Your Ref SSD-64916225
Our Ref NCA/19/2023
Contact Darren Wan
Telephone 9806 5565
Email dwan@cityofparramatta.nsw.gov.au

7/10/2025

**COUNCIL SUBMISSION
EXHIBITION OF AMENDED STATE SIGNIFICANT DEVELOPMENT APPLICATION – WSU
INDIGENOUS CENTRE OF EXCELLENCE (171 VICTORIA ROAD, PARRAMATTA)**

Signage is proposed to the north elevation of the building addressing Victoria Road and the Railway Street intersection.

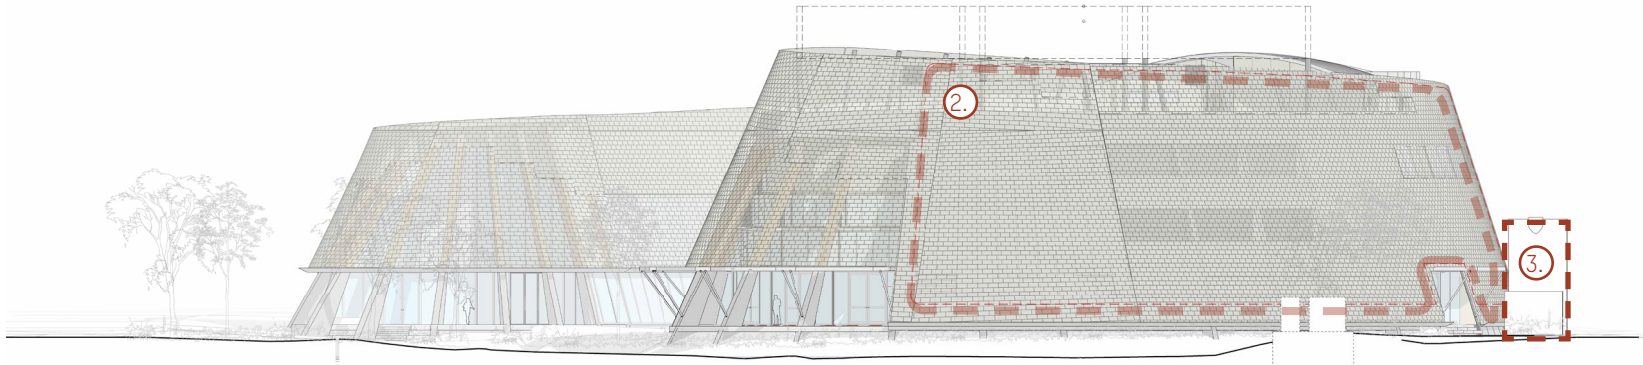
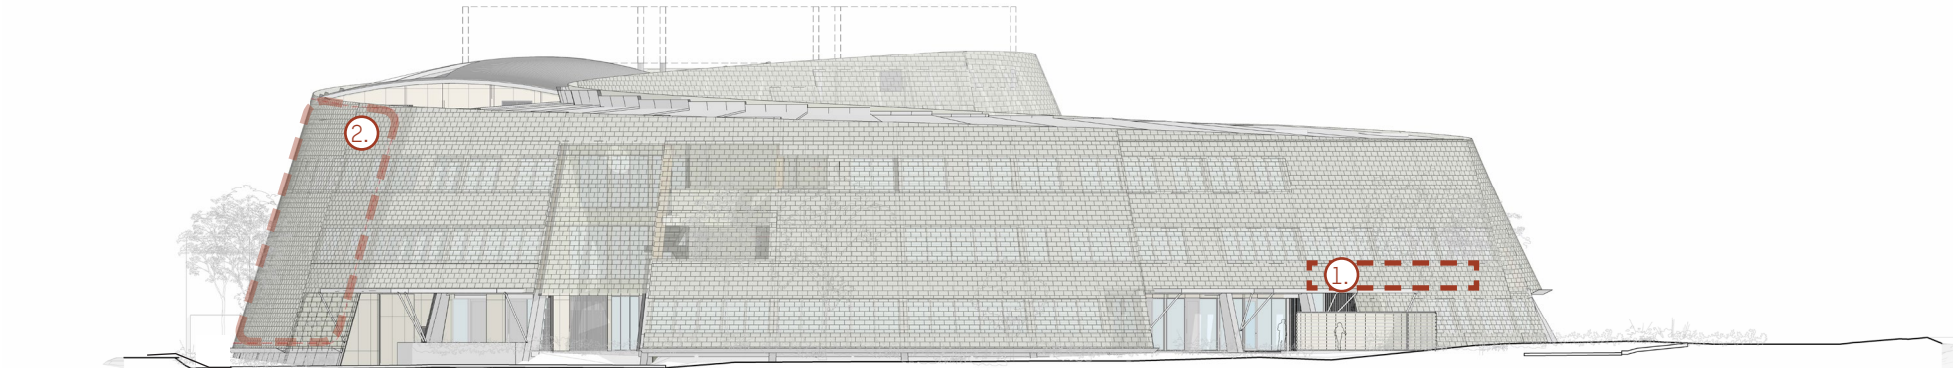
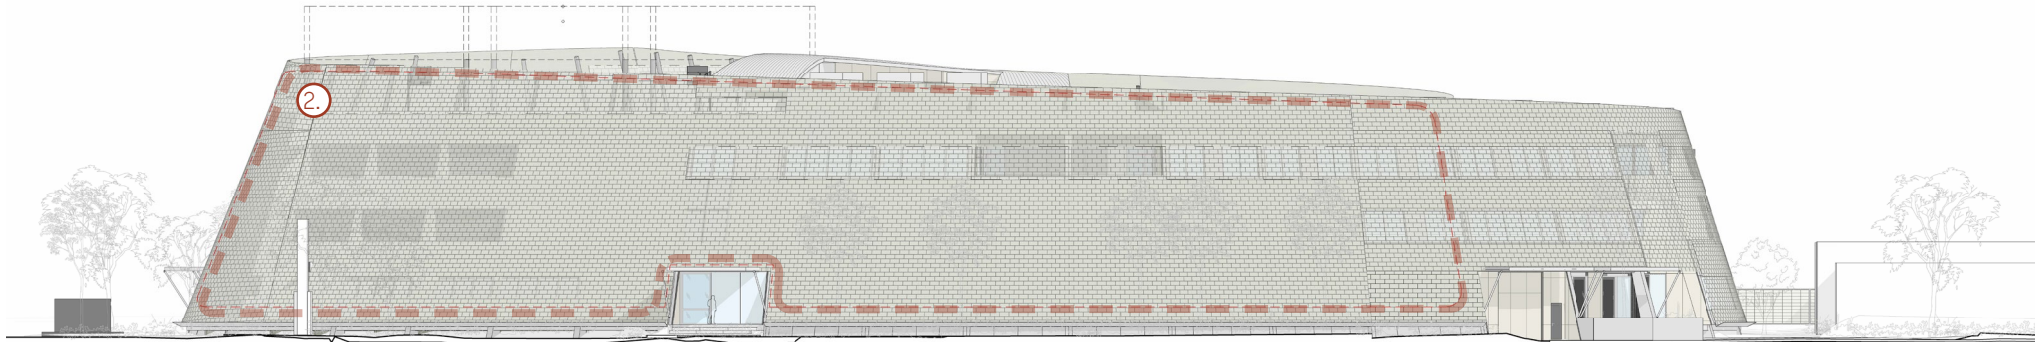
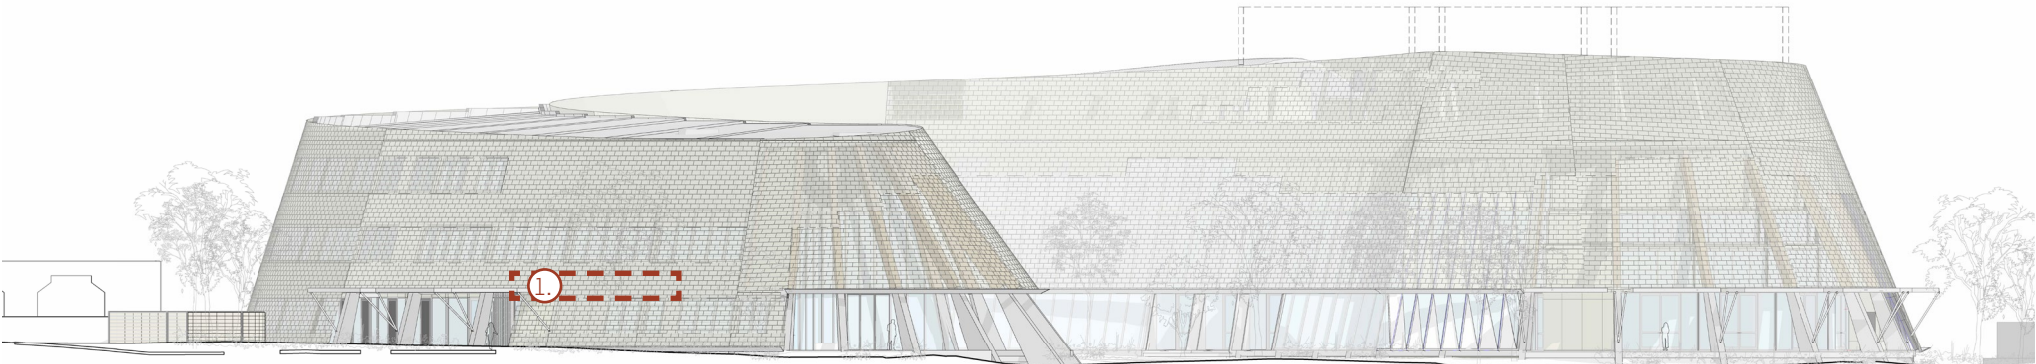
- Further design consideration is still recommended to reduce the building's perceived bulk and scale through modulation and articulation, while maintaining the intended continuity through the use of a singular material.
- A more refined signage zone that occupies less of the façade is recommended to ensure the material and architectural expression remain prominent.

Figure 2 - City of Parramatta Council stormwater drainage system diagram.

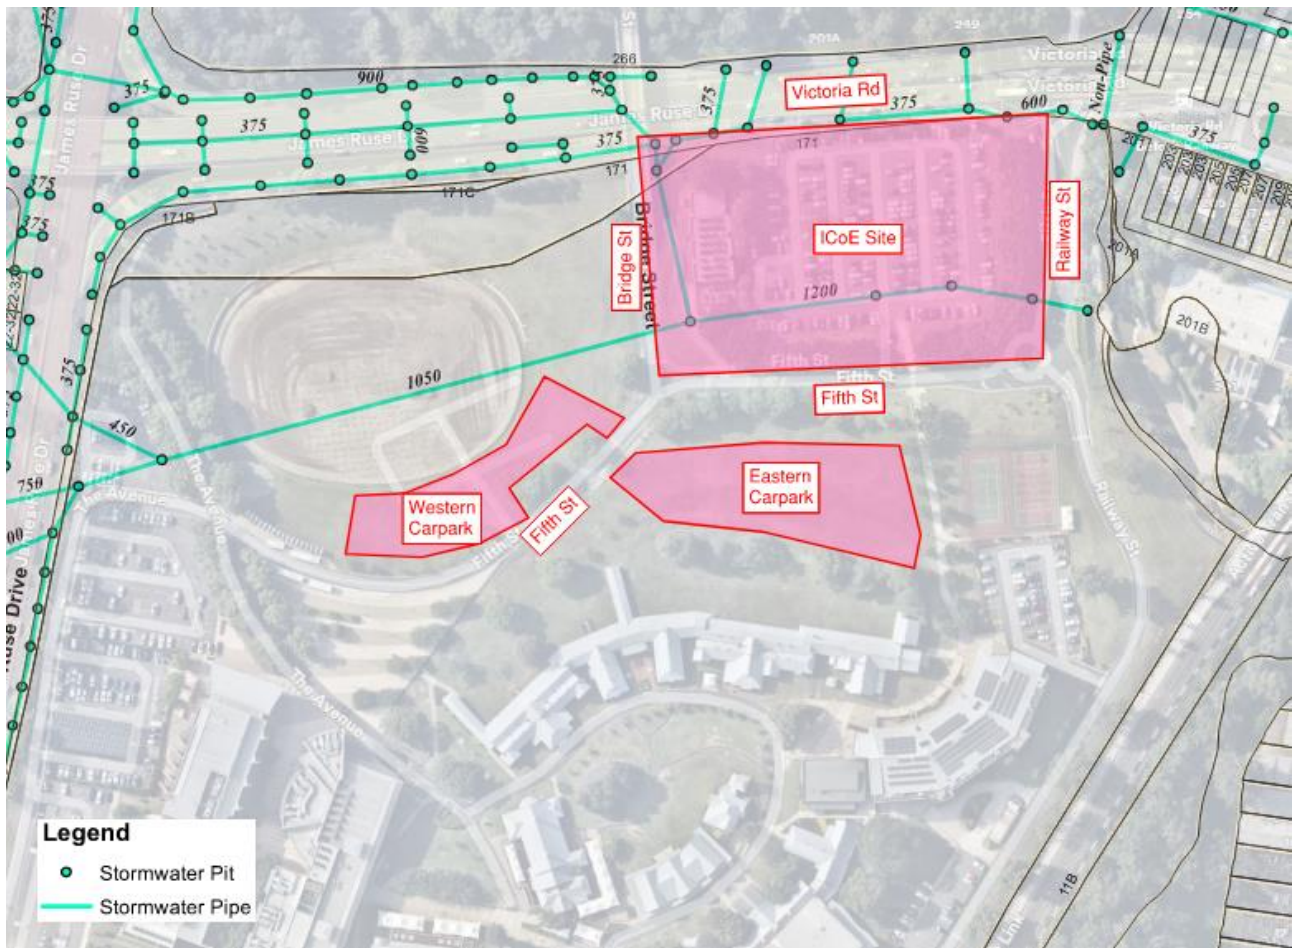
The revised proposal retains a 1200 mm diameter Council pipe beneath the building, with two new inspection pits. This is not supported. Council pipes must be relocated outside the building footprint, with an adequate easement that is open to the sky, as per Council's Development Engineering Design Guideline 2018, section 4.5. The easement must be wide enough to allow a safe overland flow path for up to the 1% AEP event, considering climate change.

As mentioned in previous comments, a map clearly showing proposed and existing public and private stormwater/flooding assets need to be included. It should also show the owner (current/future) of the assets.
